Diane Sarkies - Objection to buses on robert road App no: SSI5414

**ATTENTION: DIRECTOR INFRASTRUCTURE PROJECTS
SUBMISSION TO NWRL RE ROBERT ROAD CHERRYBROOK
Application number: SSI-5414**

This submission is on behalf of the residents of Arundel Way Cherrybrook in relation to the future possible impact of the NWRL on Robert Road.

Figure 6.12 Cherrybrook Station - Indicative vehicle and pedestrian movements

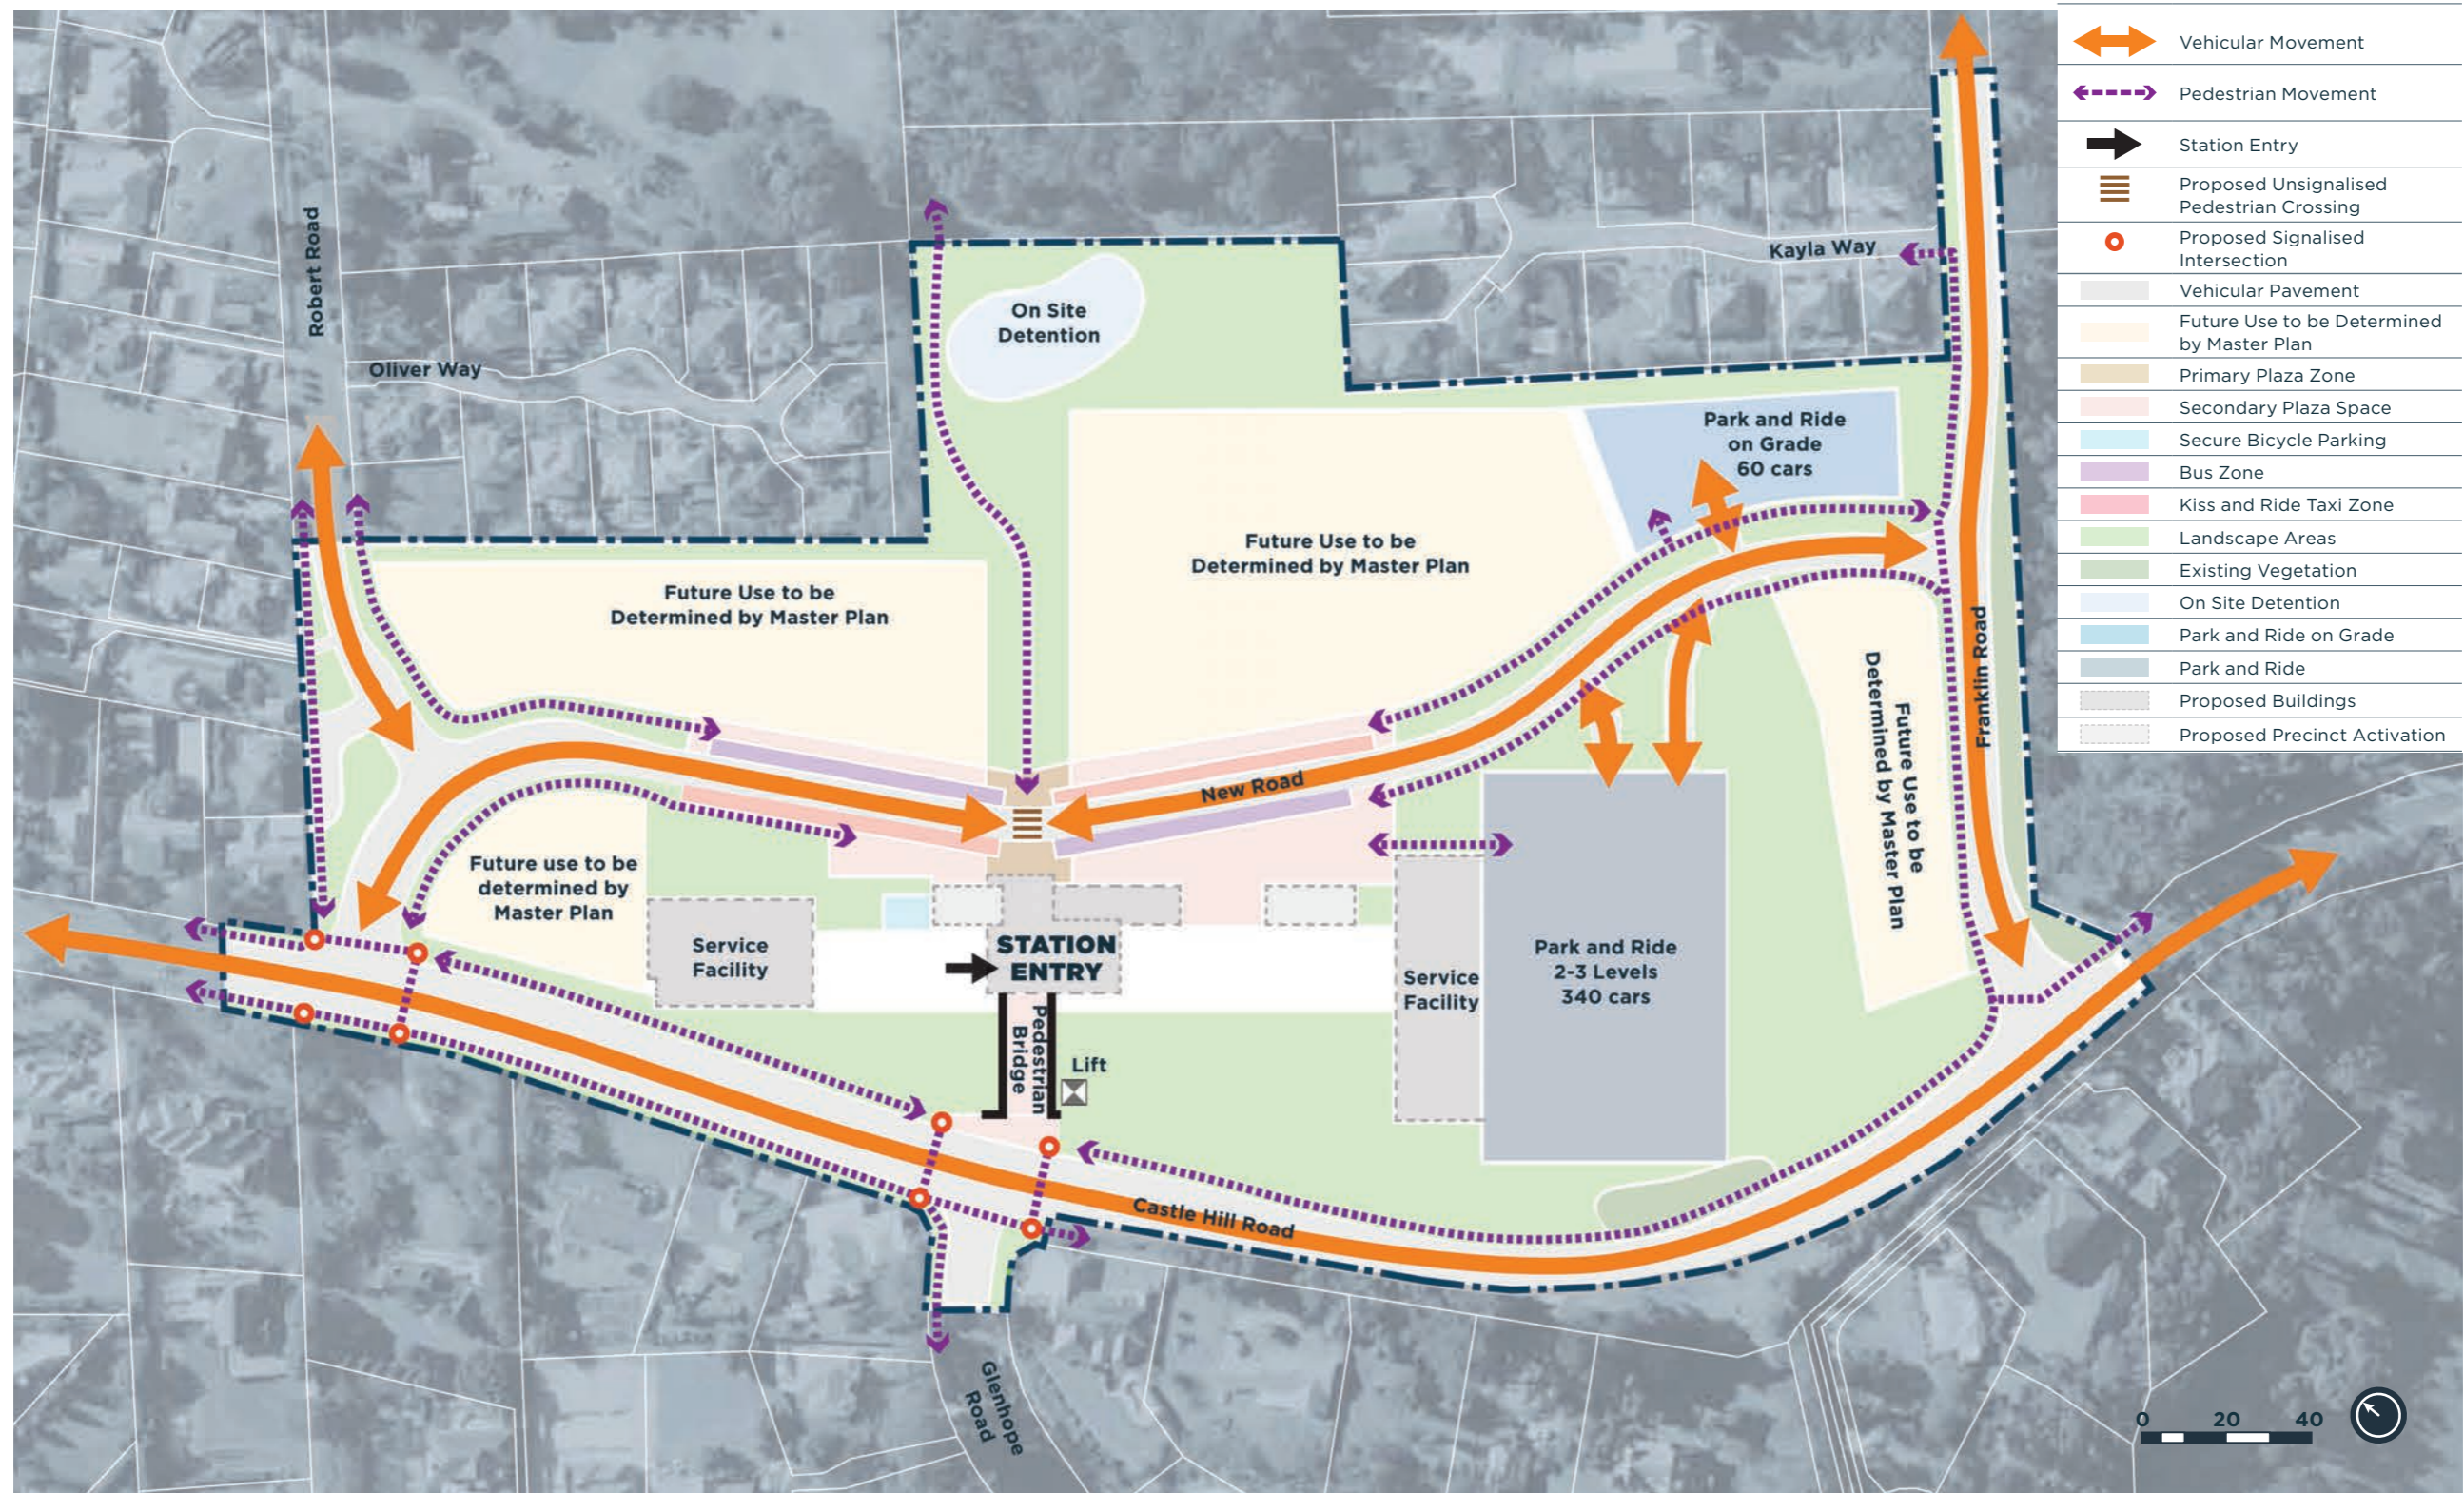
The Arundel Way residents wish to strongly object to Robert Road being used as a feeder road to the yet to be constructed Cherrybrook Railway station.

Specifically we object to public transport, notably buses, using Robert Road to access the new station.

1. Robert Road is a narrow road designed for low numbers of vehicles. It is not designed for heavy traffic, particularly large vehicles such as buses.
2. The absurdity of the proposal to use Robert Road is further highlighted by the more sensible option of using County Road and then Castle Hill Road. County Drive is clearly designed for heavy traffic. Robert Road is not. We therefore propose that buses heading south on County Drive continue and turn left into Castle Hill Road and head towards Cherrybrook station, instead of the NWRL proposal of buses heading south on County Drive turn left into John Road and right into Robert Road and then south into Robert Road and onto Cherrybrook Station.

3. Contrary to the NWRL proposal, traffic heading South on County drive turning left into Castle Hill Road at peak traffic times encounters very little traffic. And traffic heading east on Castle Hill Road in morning peak time does not slow down until after the station site has been passed. Traffic turning right onto Castle Hill Road does encounter delays, but this is in the opposite direction!

4. Safety issues are paramount. Robert Road is a quiet street, with pedestrians crossing the road at many points, and often, to get access to the park at the corner of Dalkeith Road. No pedestrian crossing exists.

5. Cars existing Arundel Way will not be able to exit safely. The increased traffic of large vehicles will obstruct vision. This also applies to residents of other cul-de-sacs off Robert Road such as Louise Way and Oliver Way. Accidents are bound to happen with the toxic combination of large vehicles and a narrow street.
